Recommendation Report for Planning Permission for Works or Extension to a Dwelling

REF NO: AB/44/21/HH

LOCATION: Fern Cottage
5A Surrey Street
Arundel
BN18 9DT

PROPOSAL: Proposed loft conversion (This application may affect the setting of the Arundel Conservation Area).

The Health and Safety Executive is to be notified as soon as possible before construction work starts if the works:

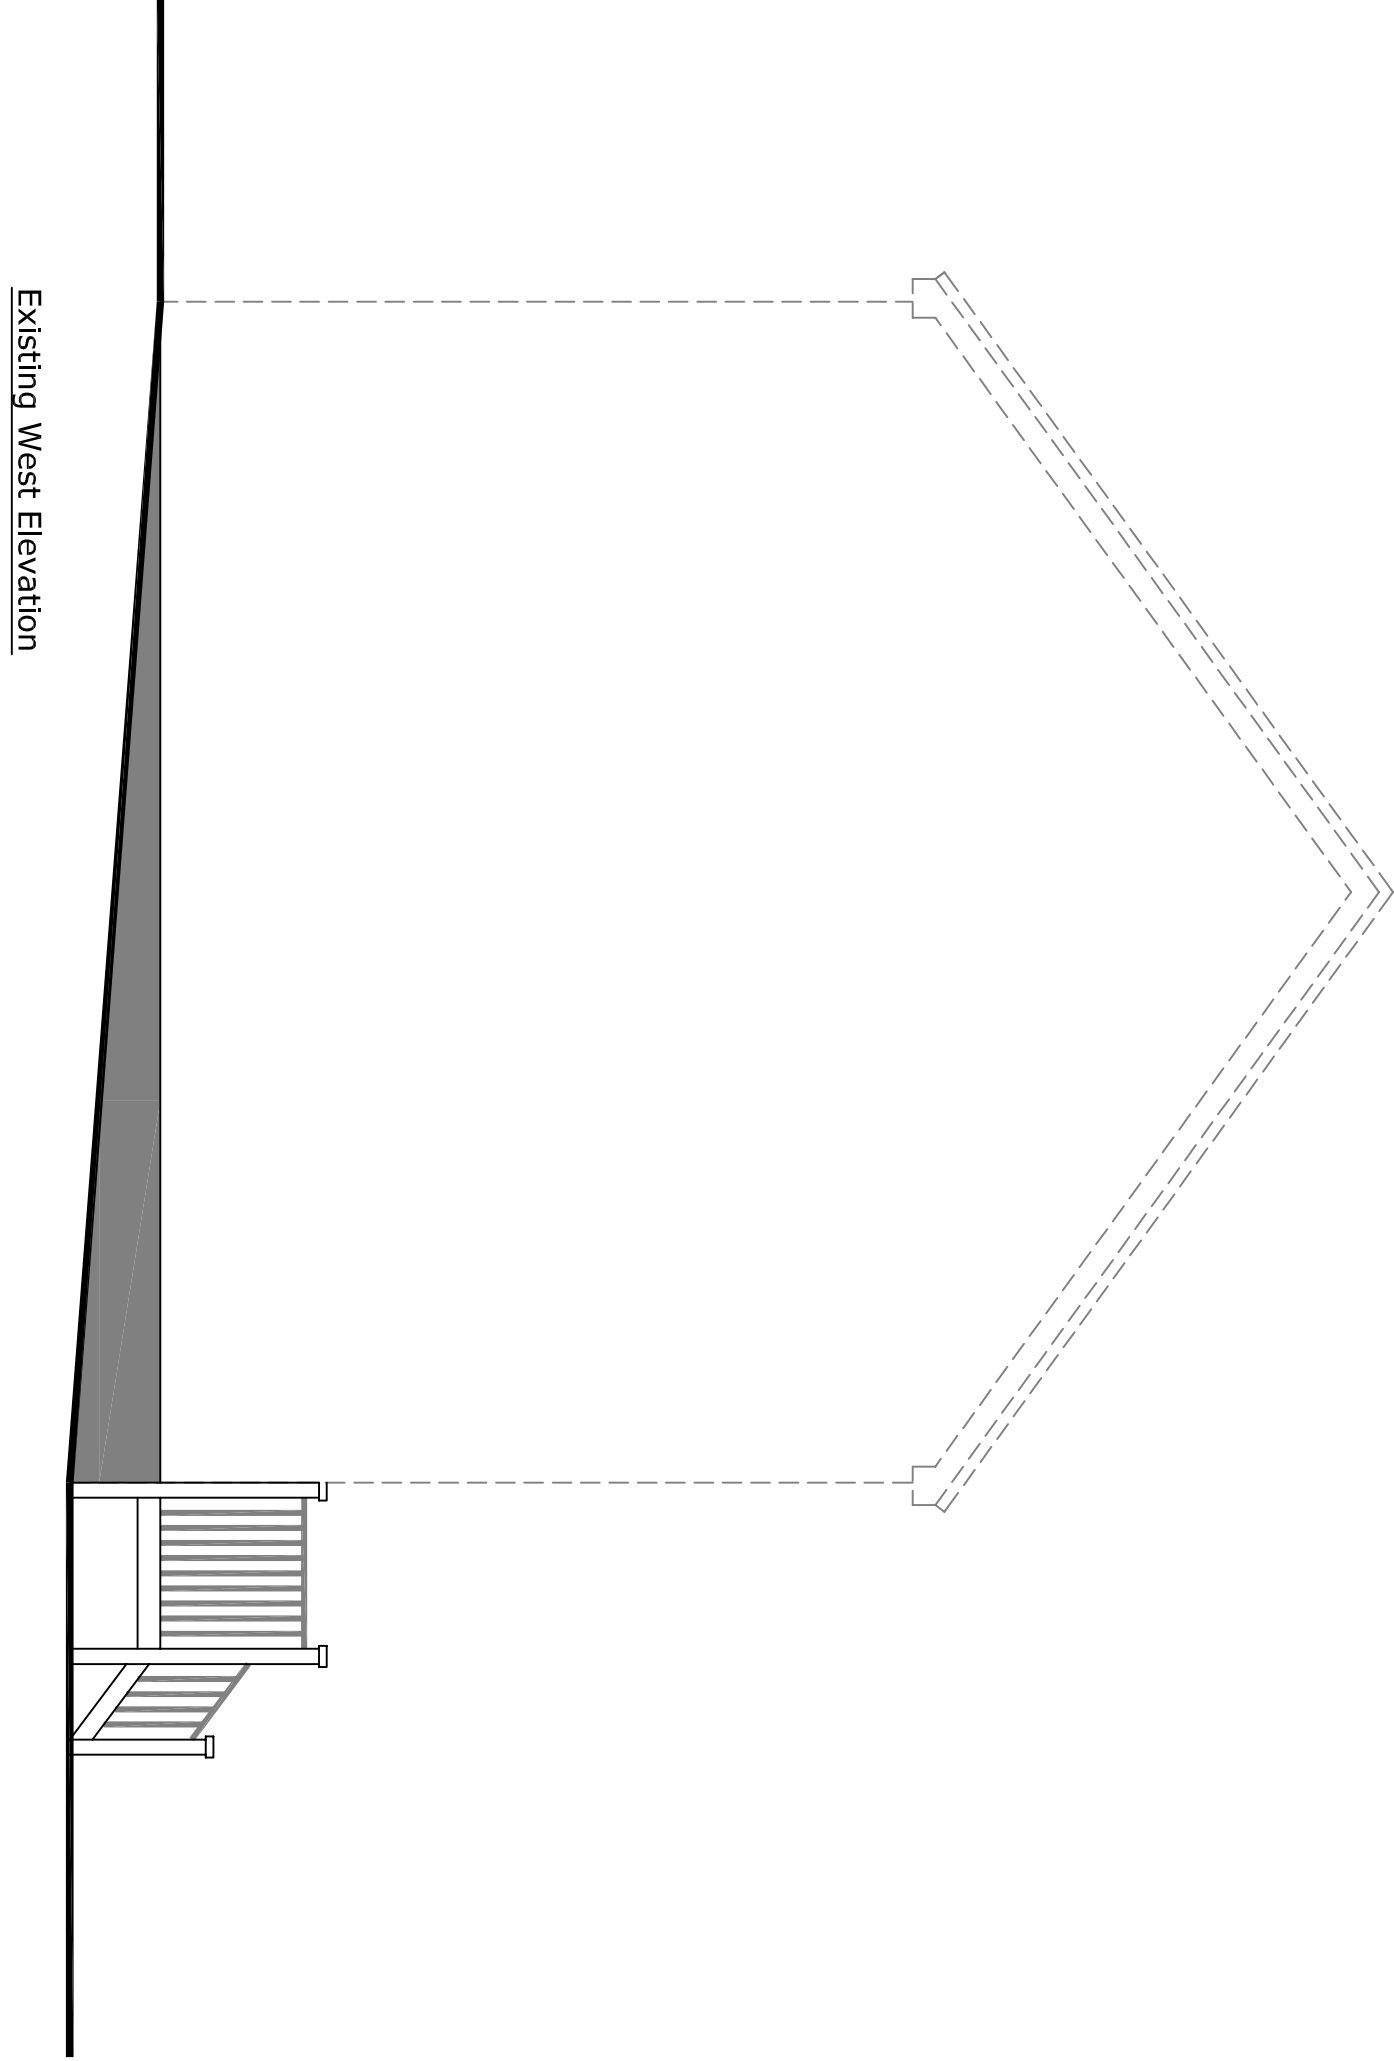
The proposal seeks to construct a rear box dormer to enable the conversion of the loft space within property, the application also seeks to install 2 roof lights to the front elevation. The resultant space will provide a new master bedroom and en-suite. To accommodate for the large dormer window the ridge of the main section of roof will be converted from a barn end to a gable, the ridge length will increase by approximately 1.1m. It is noted that there are inconsistency's in the plans as the proposed north elevation does not show this change and shows the retention of the barn end. It has also been brought to my attention that there are inconsistencies in the windowpane configuration of the elevations supplied.

Policy D DM4 of the Arun local plan requires proposals to be visually sympathetic and subservient to the character of the building and its locality. Although this building is not listed as it is of modern construction, it has been designed to mimic other buildings of significant character along Surrey Street, and it does form part of the Conservation Area. It is considered that the large box dormer is overly dominant on the building and out of character with other dormers in the area. Additionally, the application form refers to no materials being used in the external construction of the dormer, without the information relating to

materials it is impossible to comprehend if it would be visually sympathetic. However, its form and size and scale of features i.e. window, appears incongruent within the elevation, the large window on the upper floor appears top heavy.

From the street the proposal includes two large rooflights to the front elevation. The street scene forms an important feature of the conservation area, which is made up of, two-storey listed terrace cottages forming long uninterrupted roof sections. The rooflights will result in breaking up the roof plane and therefore detracting from the character of the conservation area and terrace of listed building to the west.

The property is situated within the Arundel Conservation Area. Its northern (front) elevation abuts the street. The dormer proposed to the rear of the property can not be seen from the front however in order to accommodate the dormer the main ridge line must be changed from a barn-end to a gable, lengthening the ridge in the process. The property is part of a semidetached building. Both the existing eastern and western elevation have this barn-end therefore the alteration of one, will in effect unbalance the look of the building.

More significantly to the Conservation Area is the insertion of two large roof lights to the northern elevation. The roof lights will have the effect of breaking up the uninterrupted roof plane running along the street and detract from the character of the conservation area and negatively impact the listed buildings to the west.

Paragraph 190 of the NPPF requires the council to consider the significance of the impact on the asset. The box dormer to the rear has minimal effect on the street scene, however the roof lights to the front will negatively impact the uninterrupted roof plane, at a minimum conservation roof lights would have been more appropriate.
